STATE OF NORTH CAROLINA
DEPARTMENT OF TRANSPORTATION

Addendum No. 1

RE: Contract ID C202729

Bridge Over I-40 and Approaches On NC-16

PROJECT REFERENCE NO. B-4456	SHEET NO. 5
ROADWAY DESIGN ENGINEER 	HYDRAULICS ENGINEER

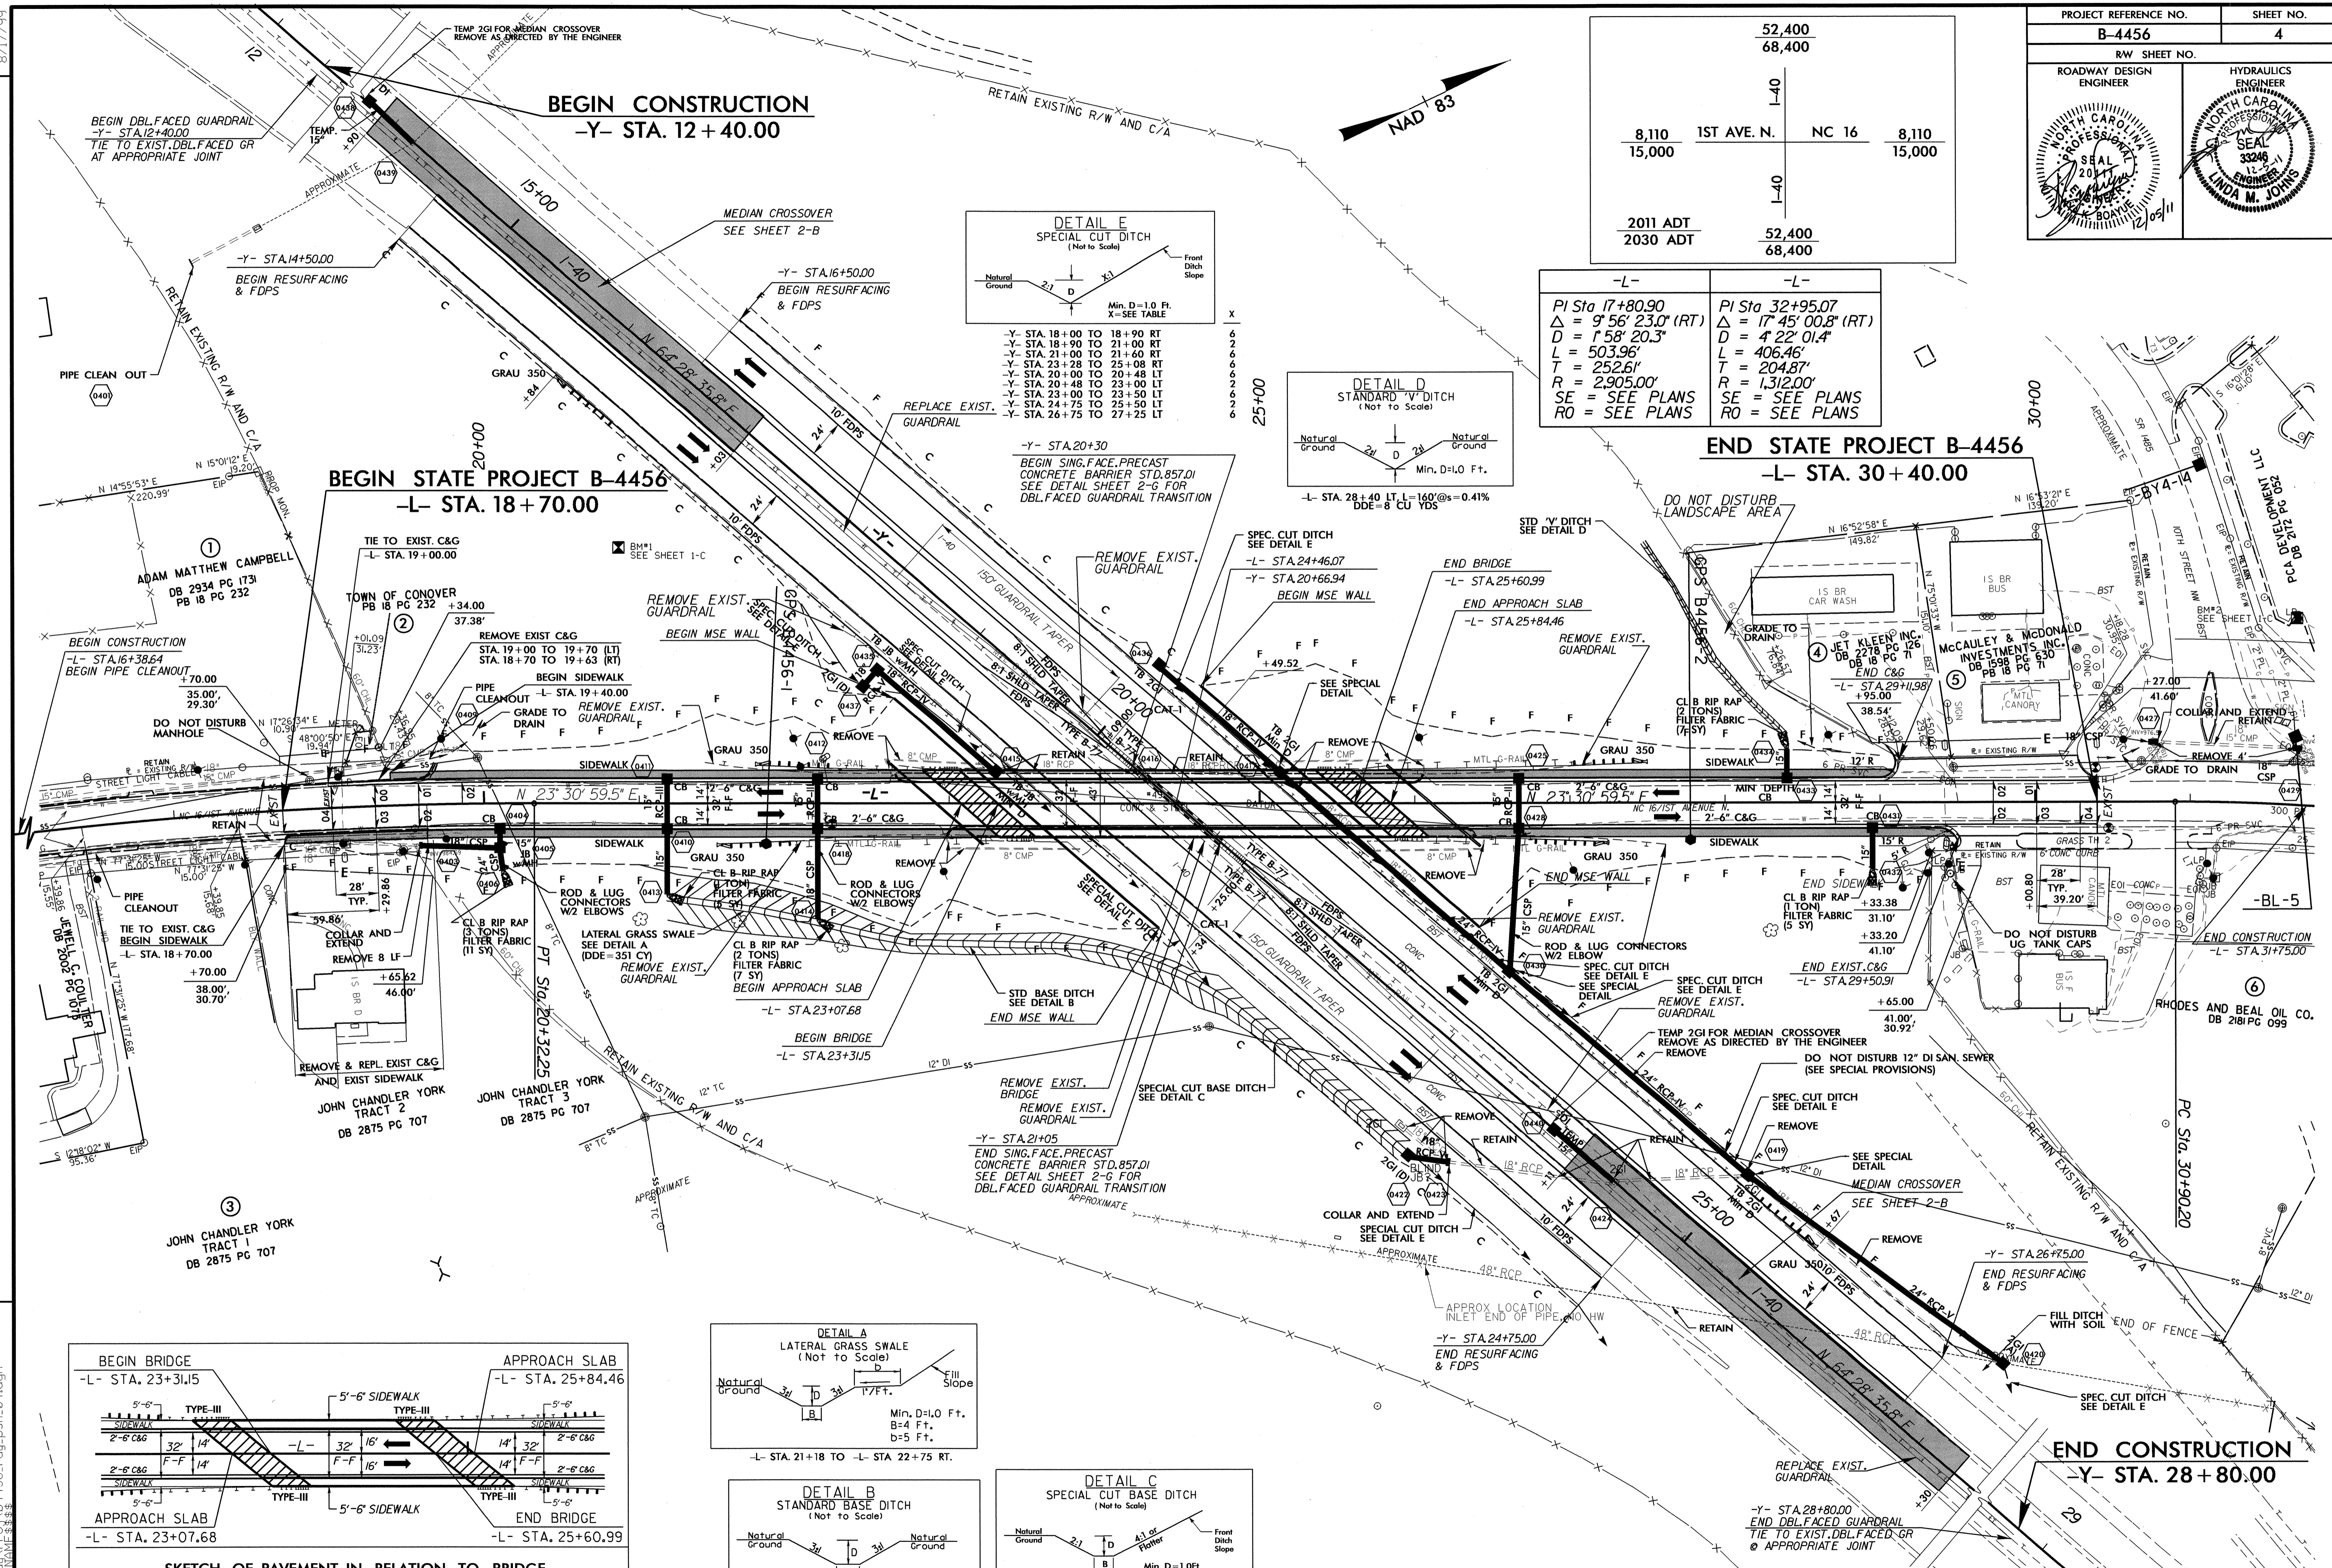
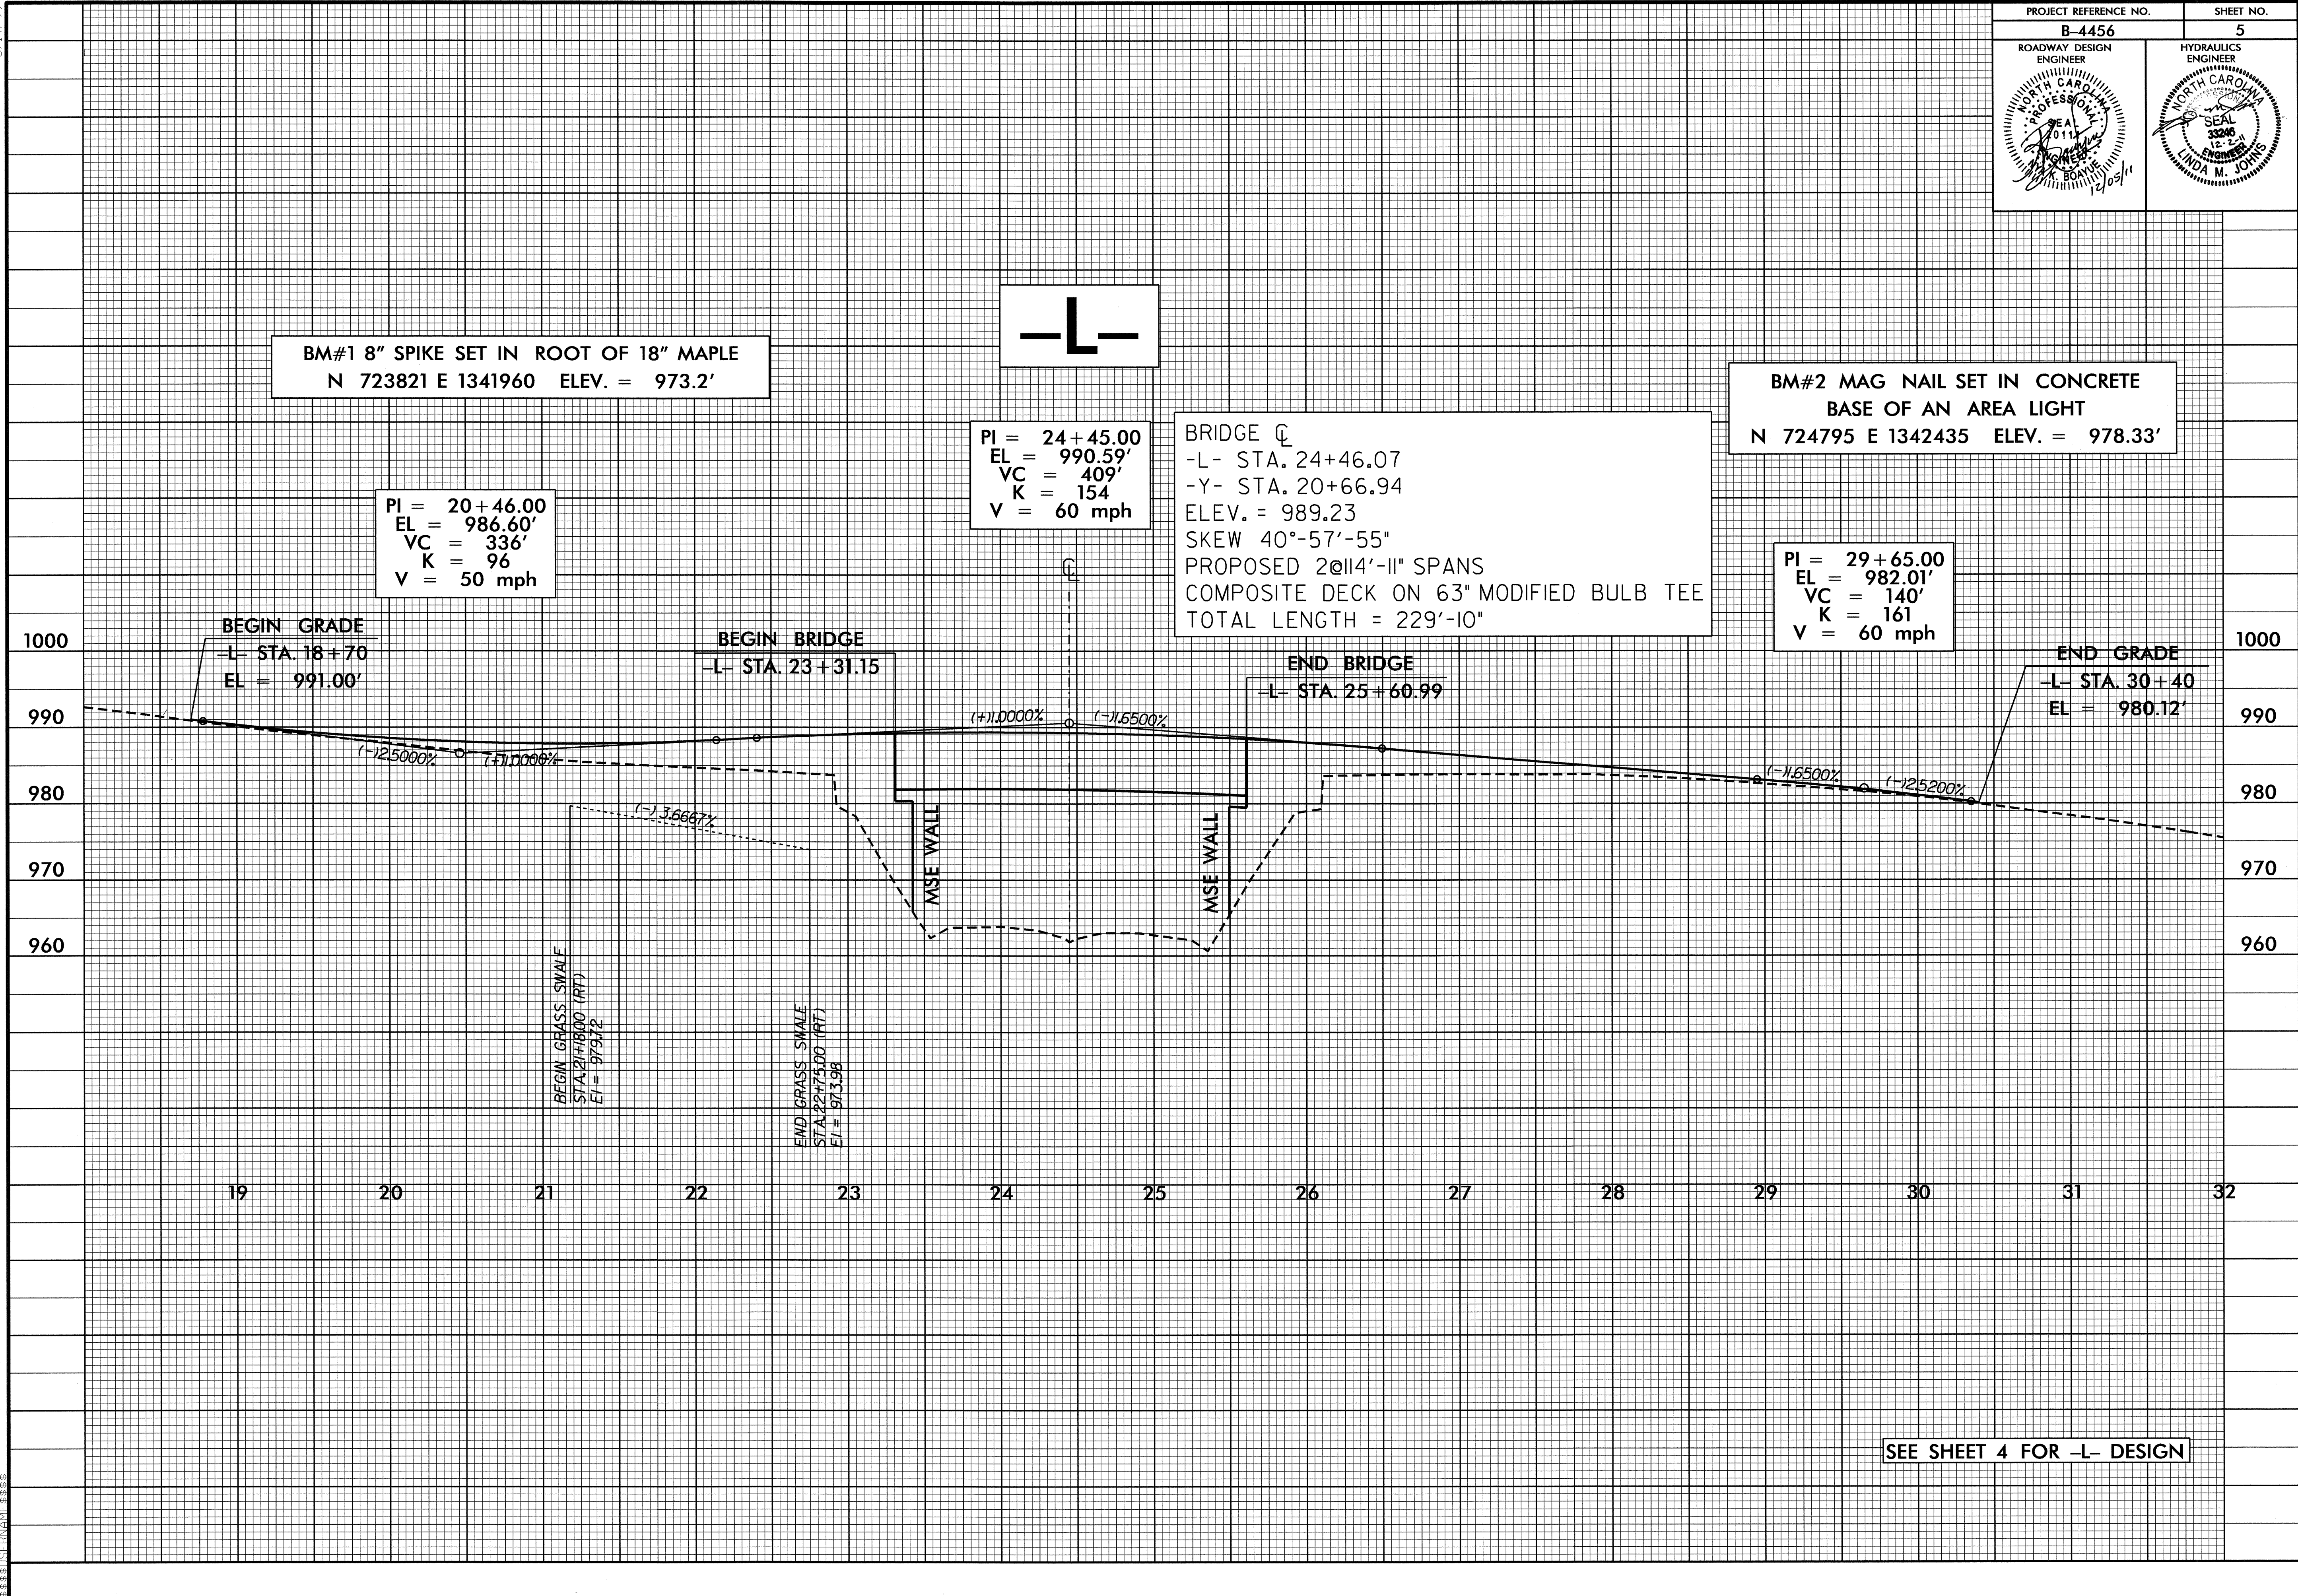
On Sheet Nos. 4 and 5 the limits of the retaining wall have been revised. Please void Sheet Nos. 4 and 5 and staple the revised Sheet Nos. 4 and 5 thereto.

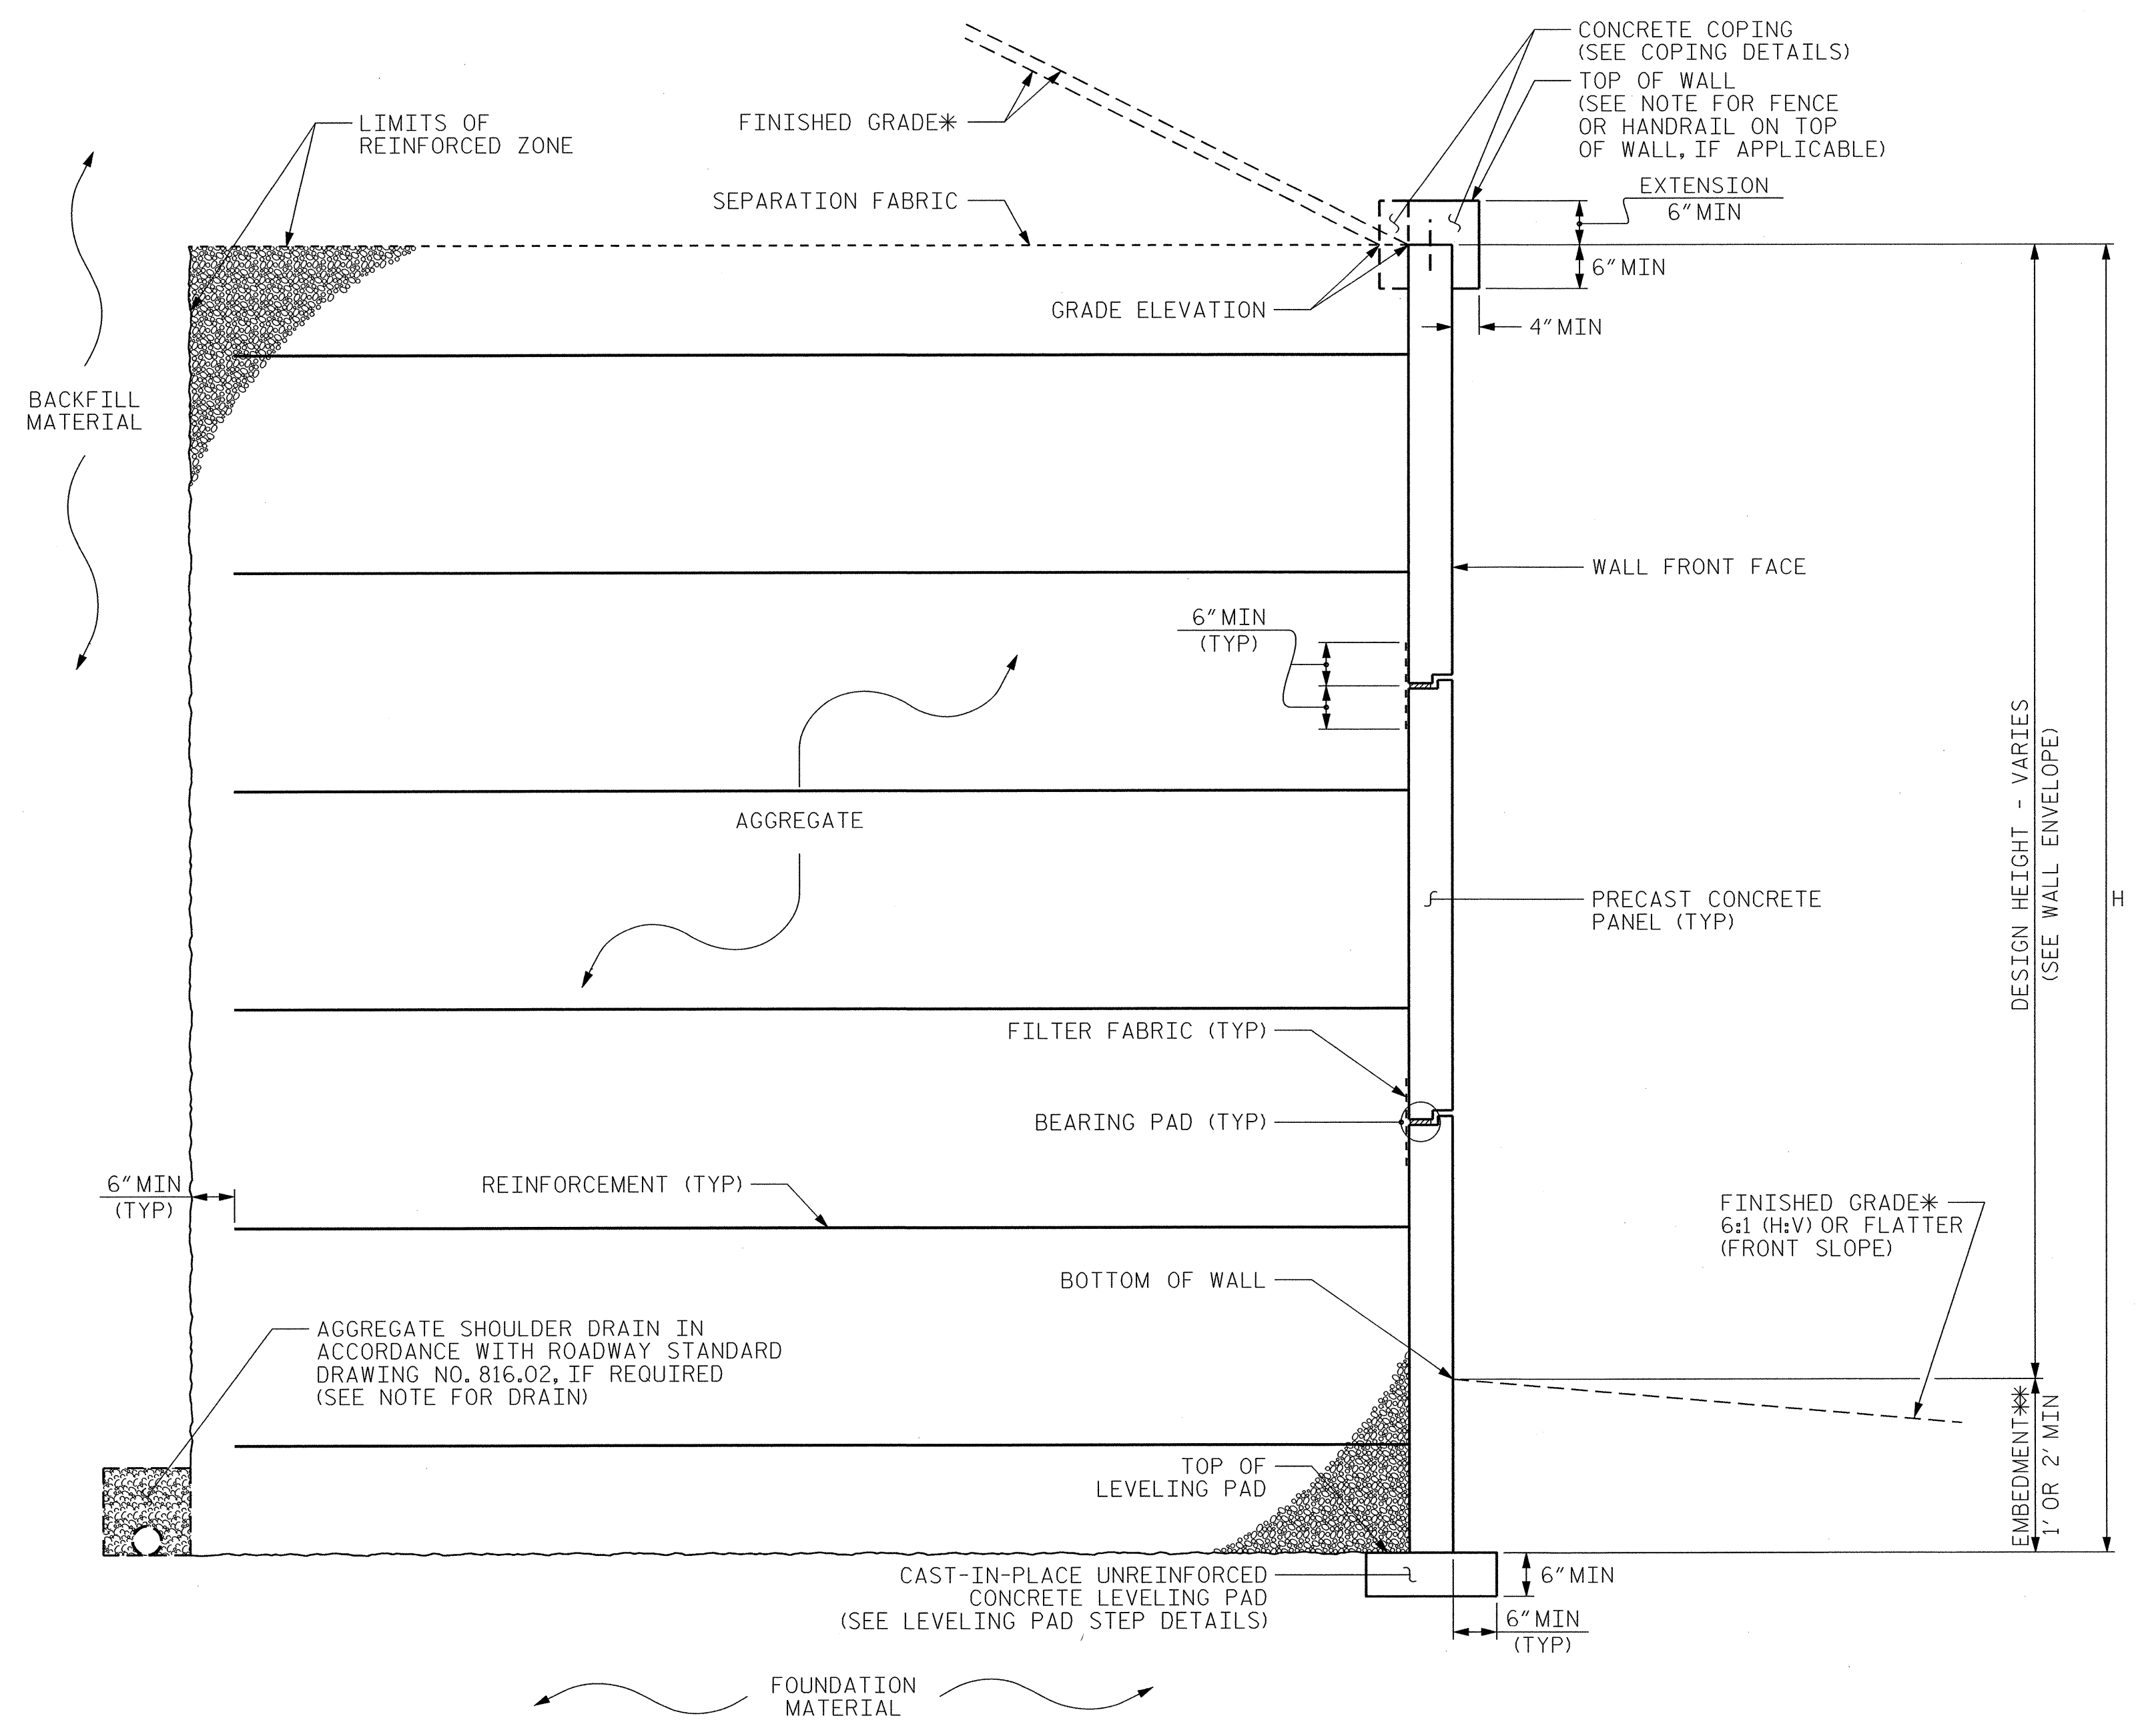
Sheet Nos. W-1 and W-2 have been revised to change the retaining wall limits. Please void Sheet Nos. W-1 and W-2 in your plans and staple the revised Sheet Nos. W-1 and W-2 thereto.
